**KIRKLEES METROPOLITAN COUNCIL
INVESTMENT & REGENERATION SERVICE**

**DELEGATED DECISION TO DETERMINE APPLICATIONS FOR
CONSENT, AGREEMENT OR APPROVAL REQUIRED BY CONDITION**

Reference No:	2025/44/90119/E
Site Address:	Yew Tree Farm, The Village, Farnley Tyas, Huddersfield, HD4 6UQ
Description:	Discharge of details reserved by conditions 3 (Phase 2 Report), 4 (Remediation Strategy), 7 (CEMP), 19 (Window Details), 21 (Roofing Materials), 22 (Walling Materials), 23 (Mortar Specification), 24 (Materials (plot 15)), 29 (Boundary Treatment) on previous permission 2021/93006 for conversion of existing barn to form 8 dwellings, erection of 9 dwellings, demolition of redundant agricultural buildings and associated works (Listed Building within a Conservation Area)
Recommending Officer:	Katie Chew

Second Officer Report

TYPICAL SECTION BOUNDARY RETAINING WALL - 1:20 @ A1

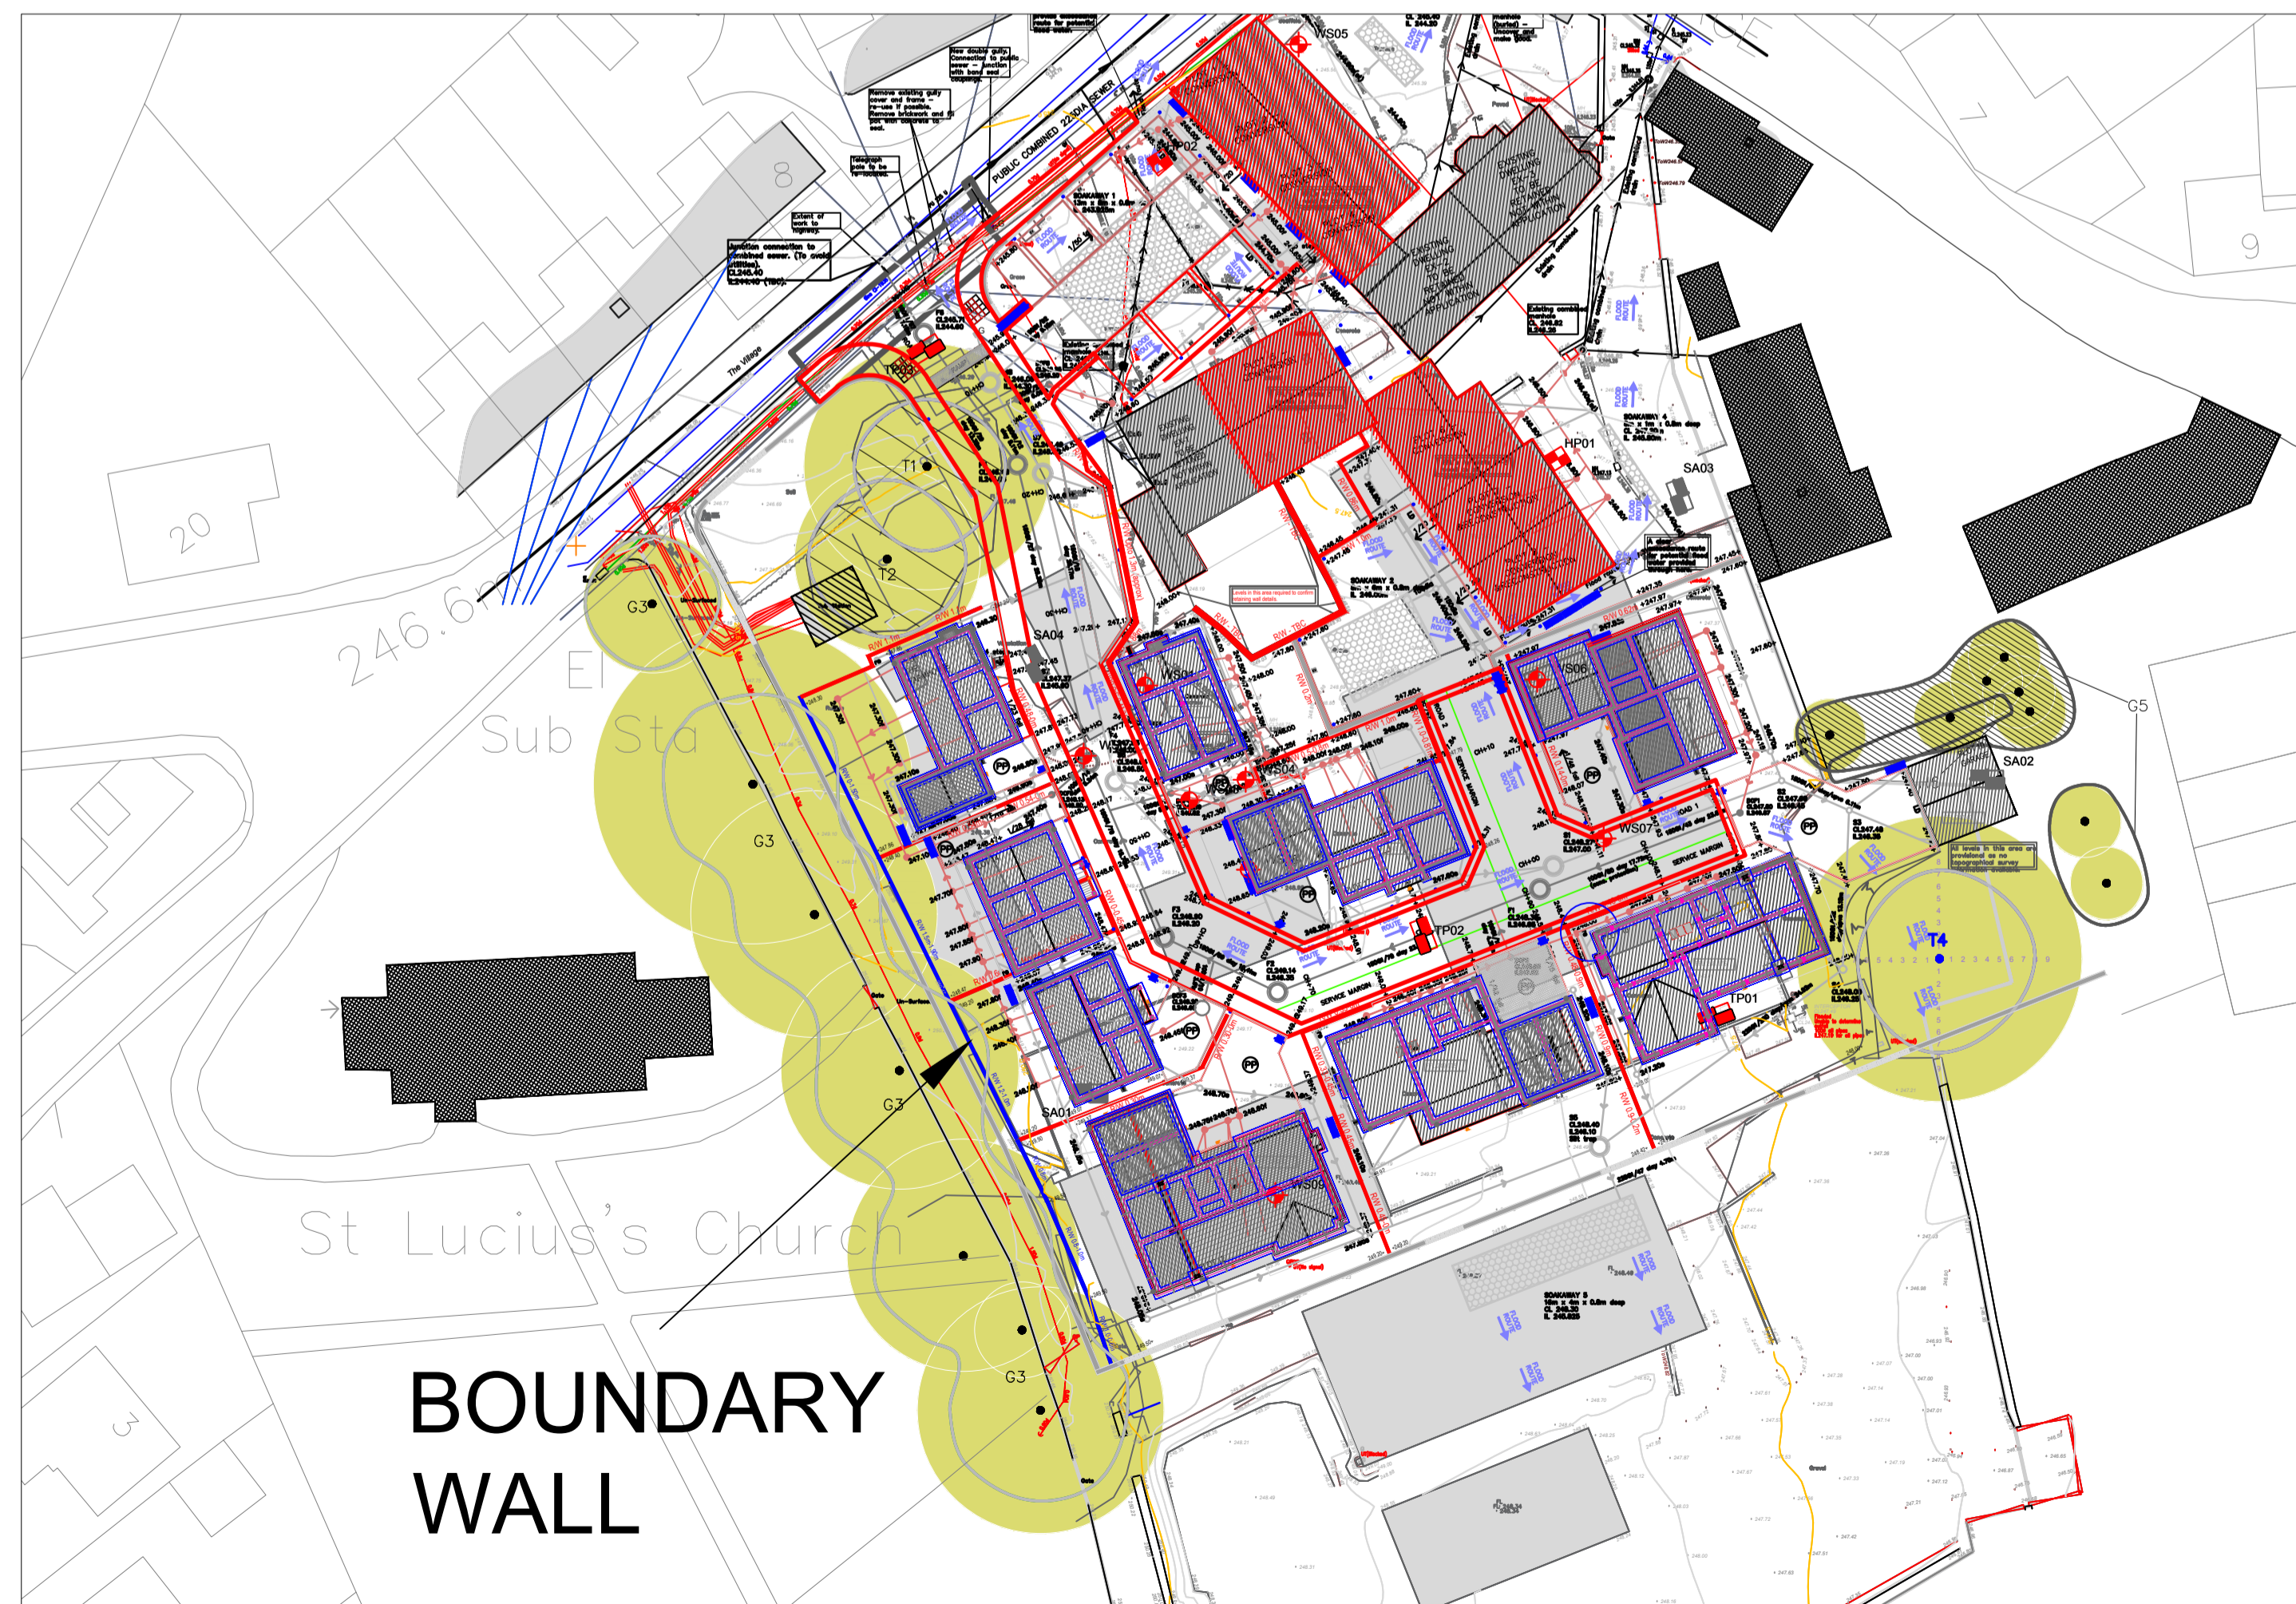
I would like to advise that condition 29 (Boundary Treatment) cannot be discharged pending the formal technical approval of design of proposed retaining walls via submission of AIP/s.

Following receipt of the above comments and the issuing of the interim letter dated 09/09/2025 (in which condition 29 was not approved / discharged) the applicant's agent sought to submit Boundary Retaining Wall, Drawing No. 1430/60 Rev AB which sought to amend the originally submitted Boundary Retaining Wall drawing to "as built" drawings, given that the wall has already been constructed.

Further to the X-sectional information, as shown on drawing no. 1430-060 Rev AB – Boundary Retaining Wall (As Built), I would like to confirm that planning condition 29 (Boundary Treatment) can now be discharged.

Officers concur with the above assessment and conclude that the previous reasons preventing the condition from being discharged have been addressed. Therefore, officers are able to recommend that the details for Condition 29 are approved.
